WEST SUSSEX COUNTY COUNCIL CONSULTATION

TO:	Arun District Council FAO: Richardd Castro-Parker
FROM:	WSCC - Highways Authority
DATE:	5 September 2019
LOCATION:	Mermaid and Playbox, Sea Road, Felpham, PO22 7AW
SUBJECT:	FP/185/19/PL Detached dwelling - Resubmission of FP/201/18/PL.
DATE OF SITE VISIT:	n/a
RECOMMENDATION:	Advice
S106 CONTRIBUTION TOTAL:	n/a

BLOCK PLAN

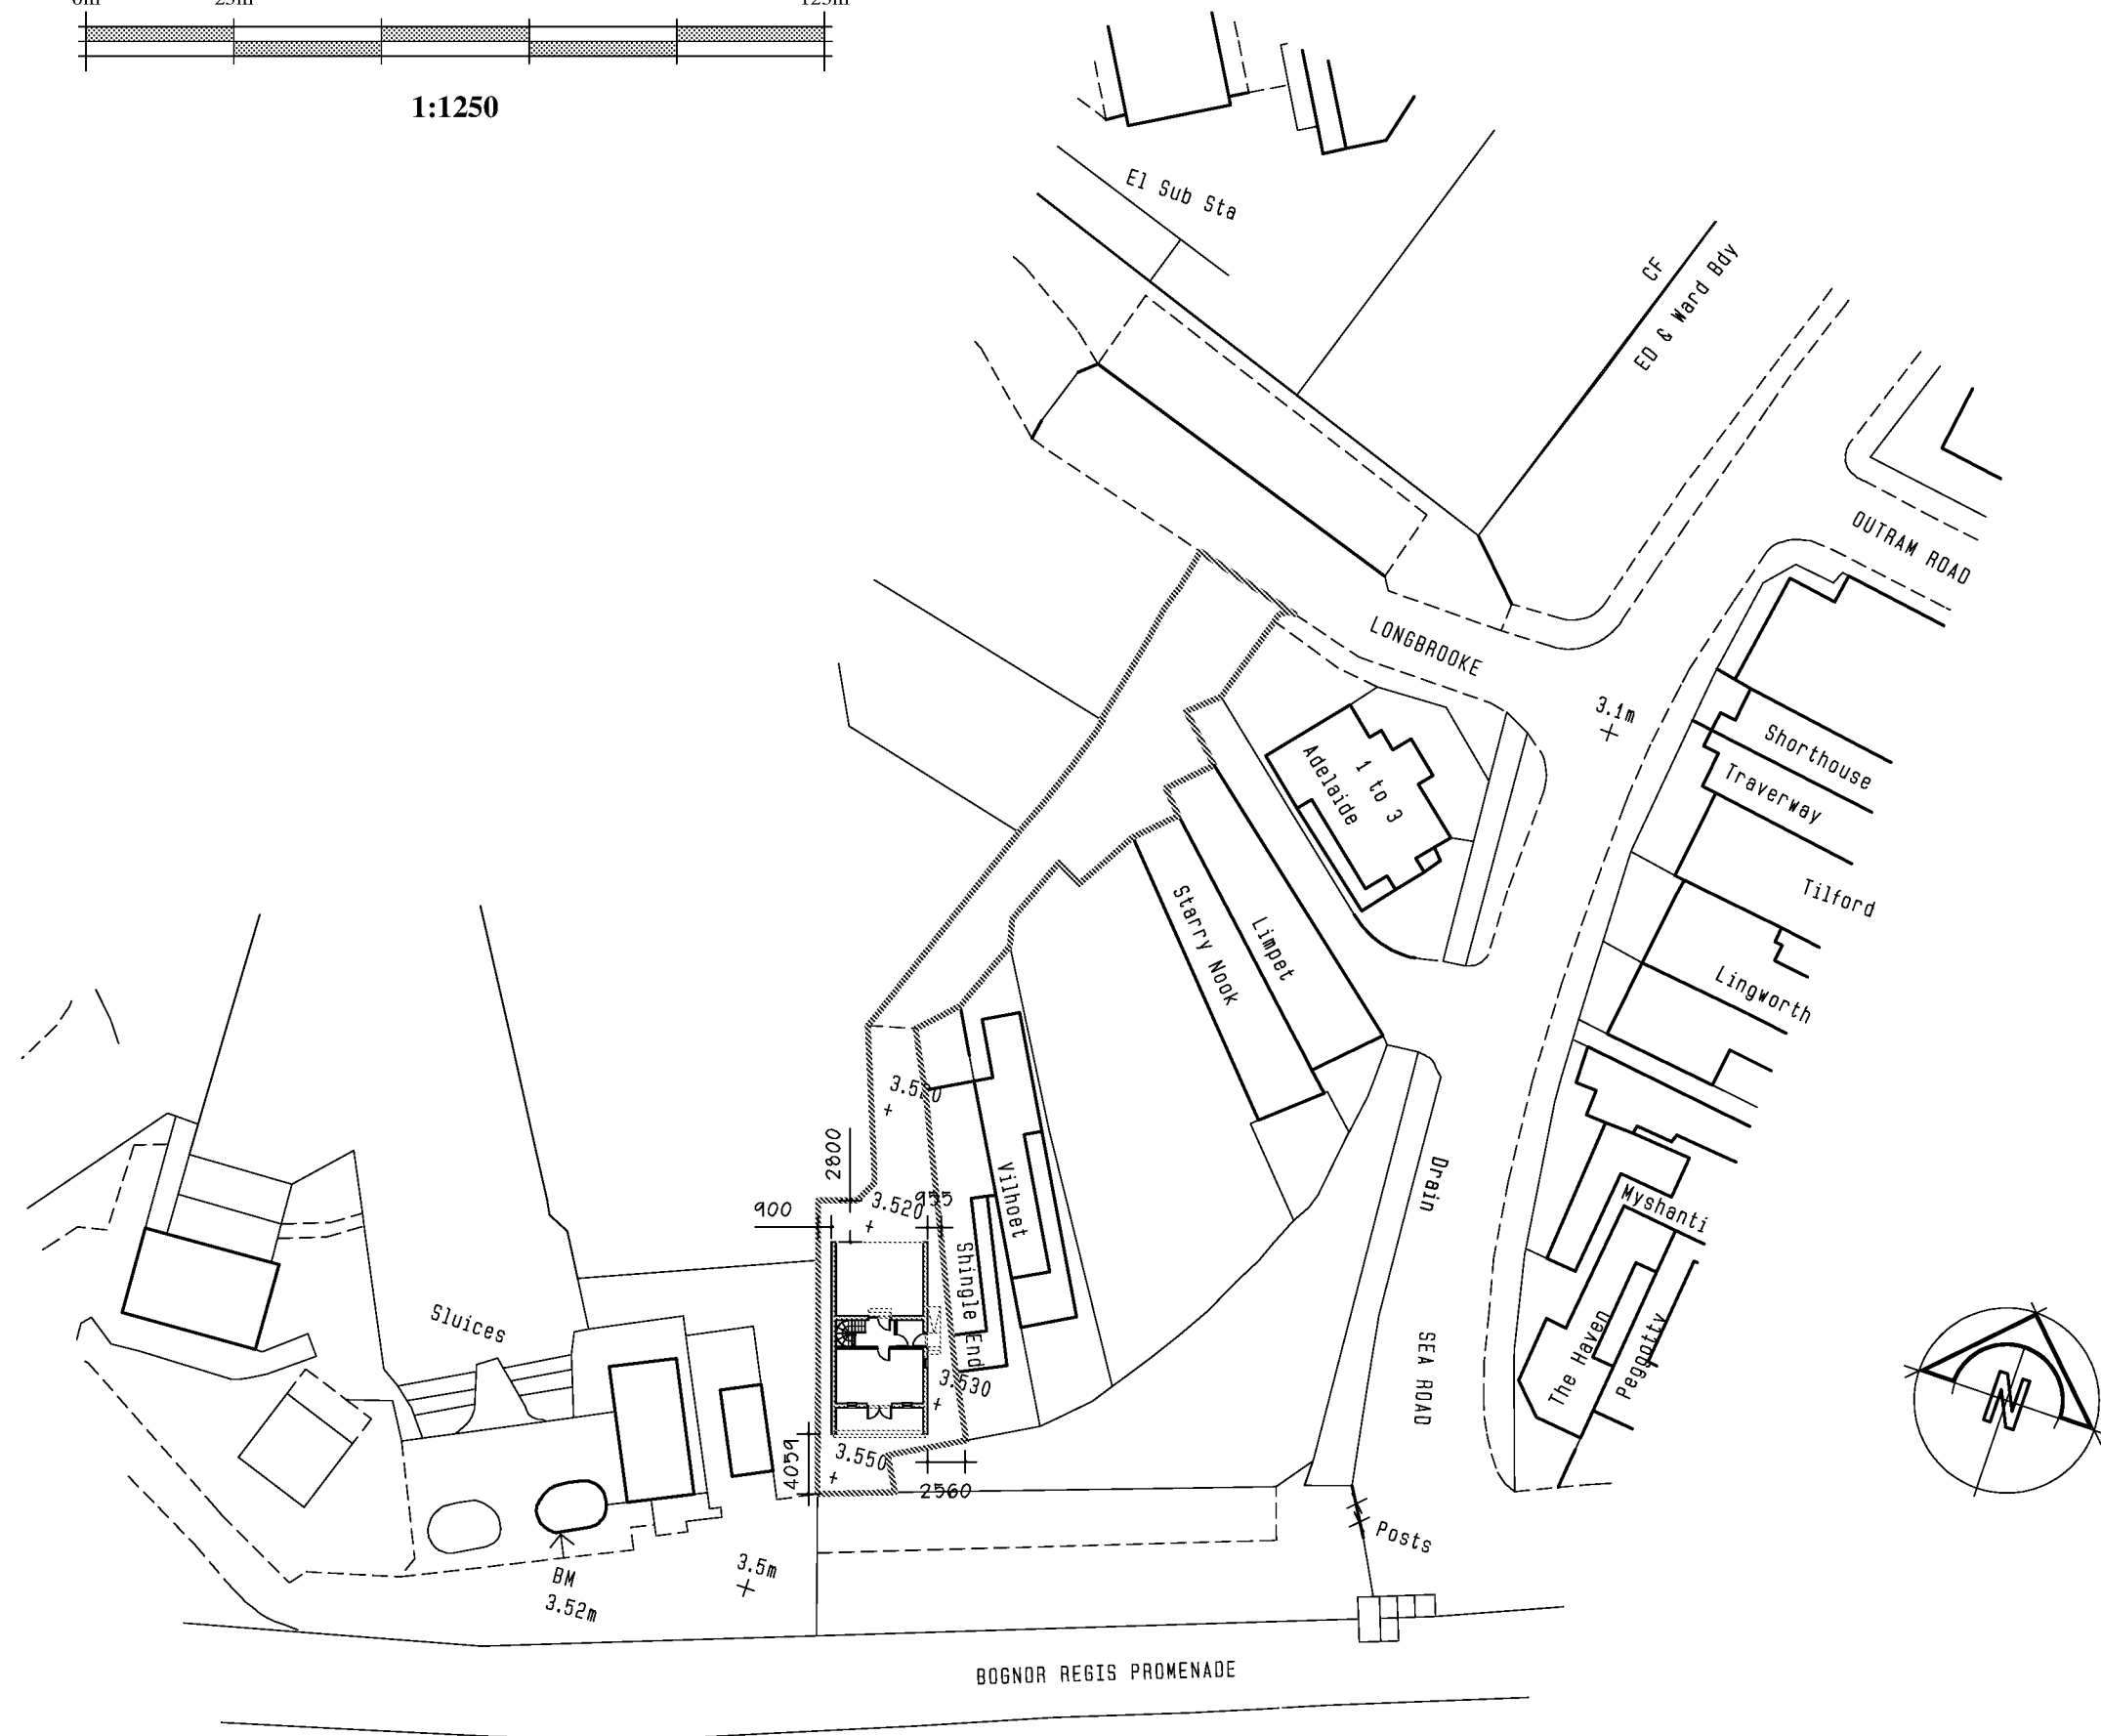
The application form does not specify details of parking on site. The proposed plans indicate that a covered parking and turning area will be provided on site, providing parking for two vehicles. These spaces appear to meet the minimum specifications as set out in Manual for Streets (MfS). The WSCC car parking demand calculator anticipates that a minimum of three parking spaces would be required for a dwelling of this size and location. Whilst there would be sufficient space on site for a third vehicle to park, this would remove the ability for vehicles to turn on site. However, the LHA would not anticipate any highway safety concerns with the lack of a turn on site, as it is expected that vehicles will enter onto the publicly maintained highway in a forward gear.

No part of the development shall be first occupied until the car parking has been constructed in accordance with the approved site plan. These spaces shall thereafter be retained at all times for their designated purpose.
